From: Chima Umunnakwe <Chima.Umunnakwe@arun.gov.uk>
Sent: 20 October 2021 19:20
To: Planning.Responses <Planning.Responses@arun.gov.uk>
Cc: Simon Davis <Simon.Davis@arun.gov.uk>
Subject: R/246/21/PL

I have reviewed the submitted details, and I can advise that sufficient information has not been provided to address potential issues relating to noise and odour from the proposed scheme. The applicant has provided some statements relating to the points mentioned. However, I do not consider that the information before me demonstrates that the complaint will not arise due to the proposed extraction system.

PLAN VIEW, ROOF, PROPOSED

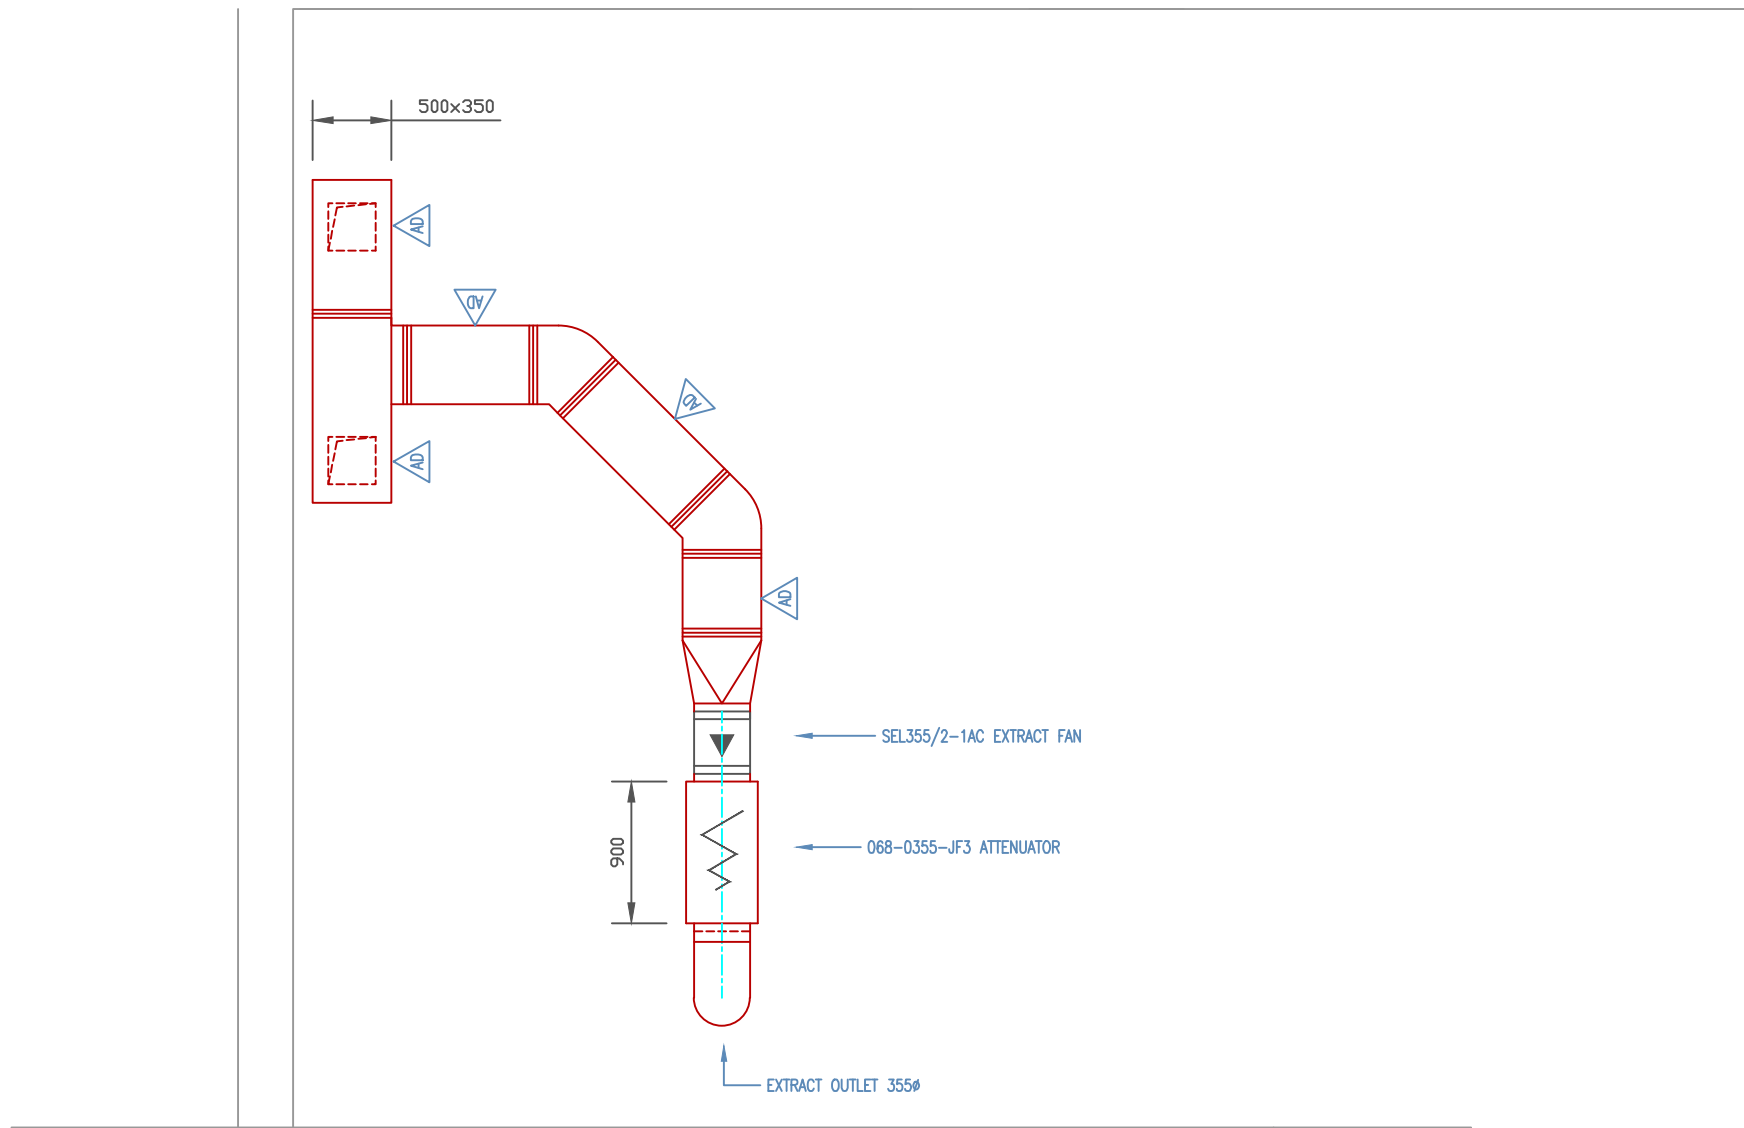
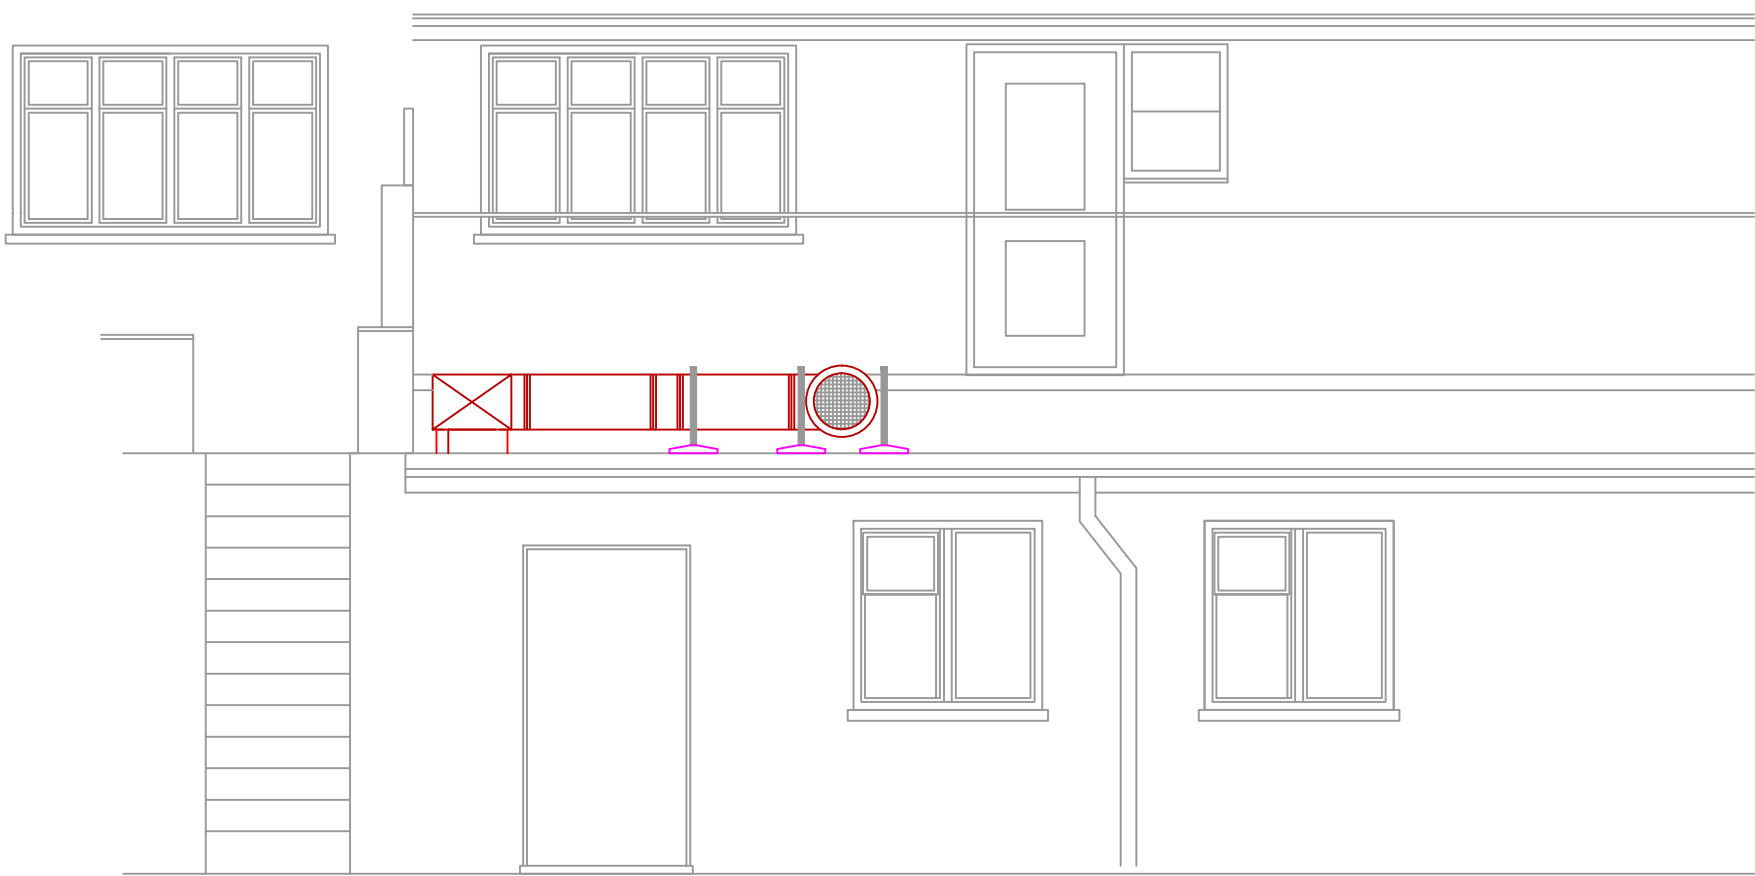
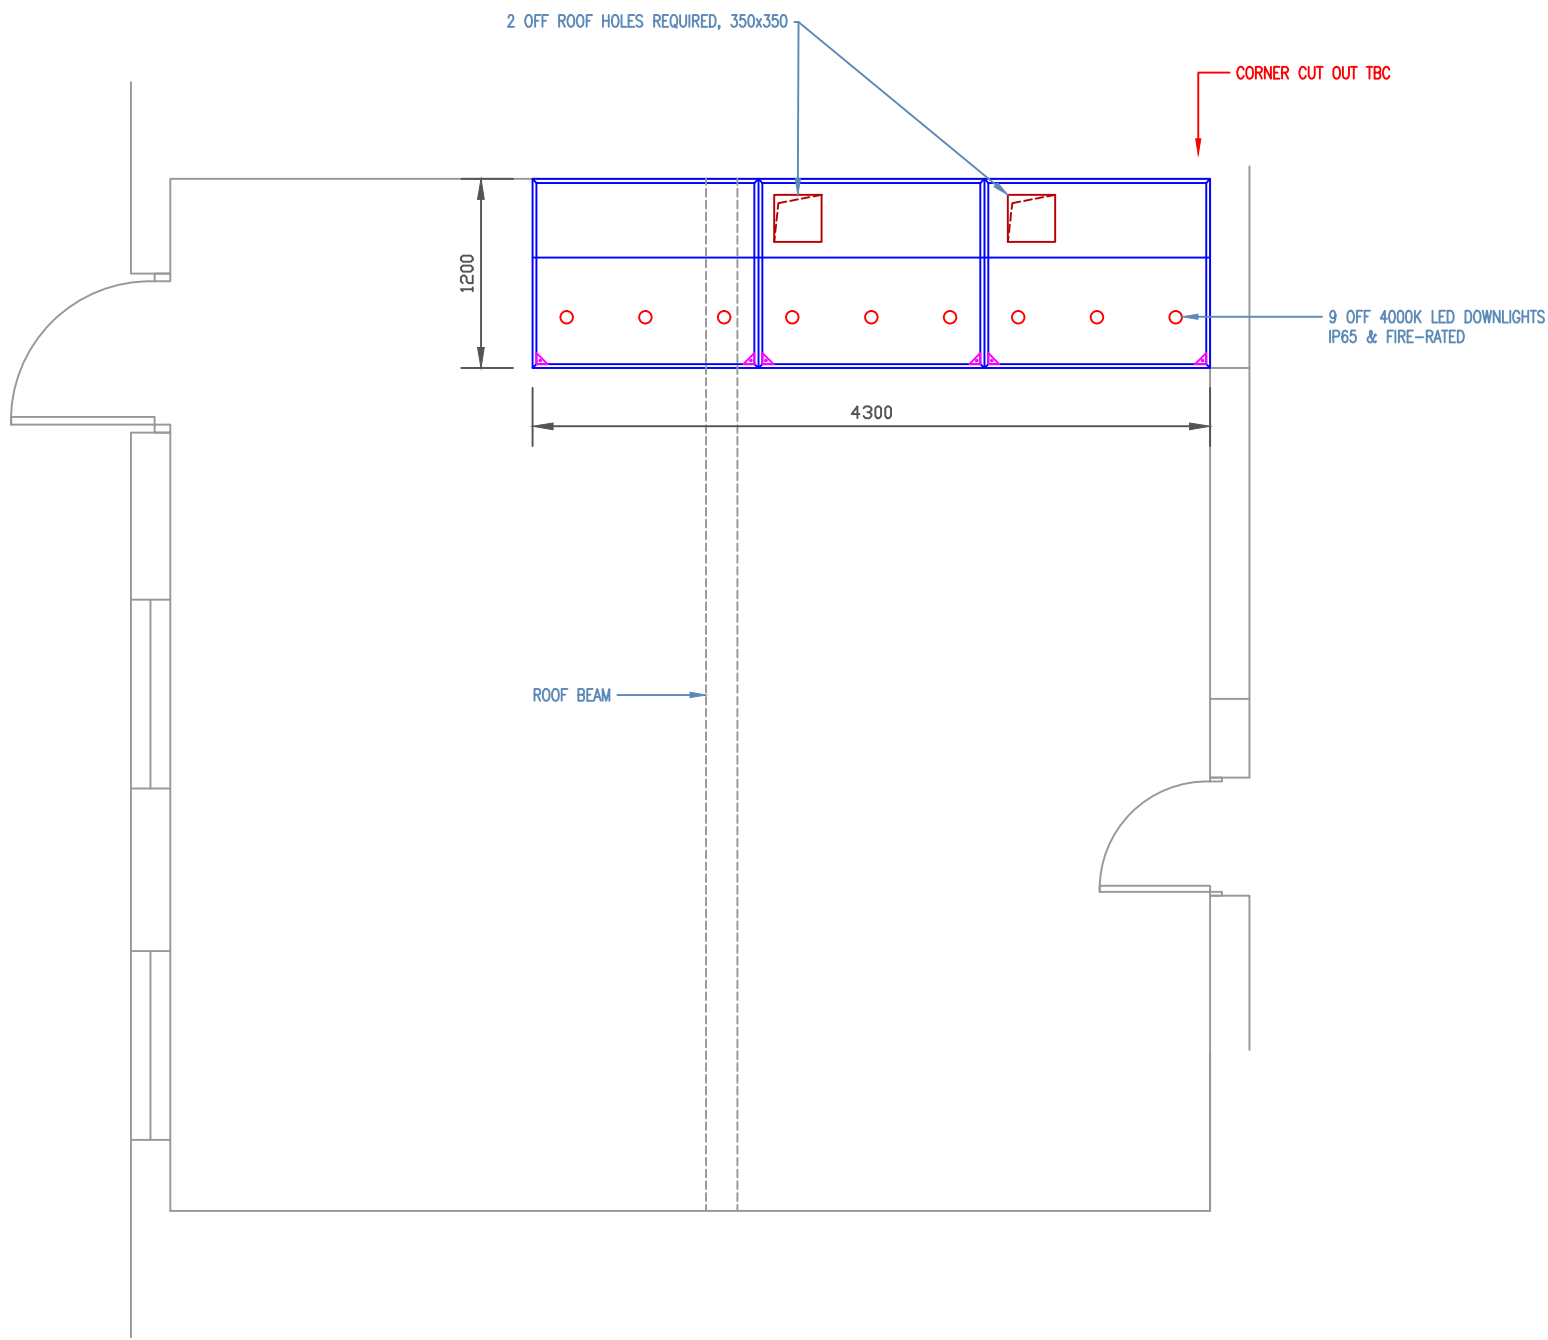
Considering the proximity of flats in the location of the proposed extractor system, the applicant needs to carry a noise assessment based on the guidance found in BS4142 2014. Any odour neutralising mechanism should conform to the defunct guidance given by The Control of Noise and Odour from commercial kitchen exhaust system by DEFRA.
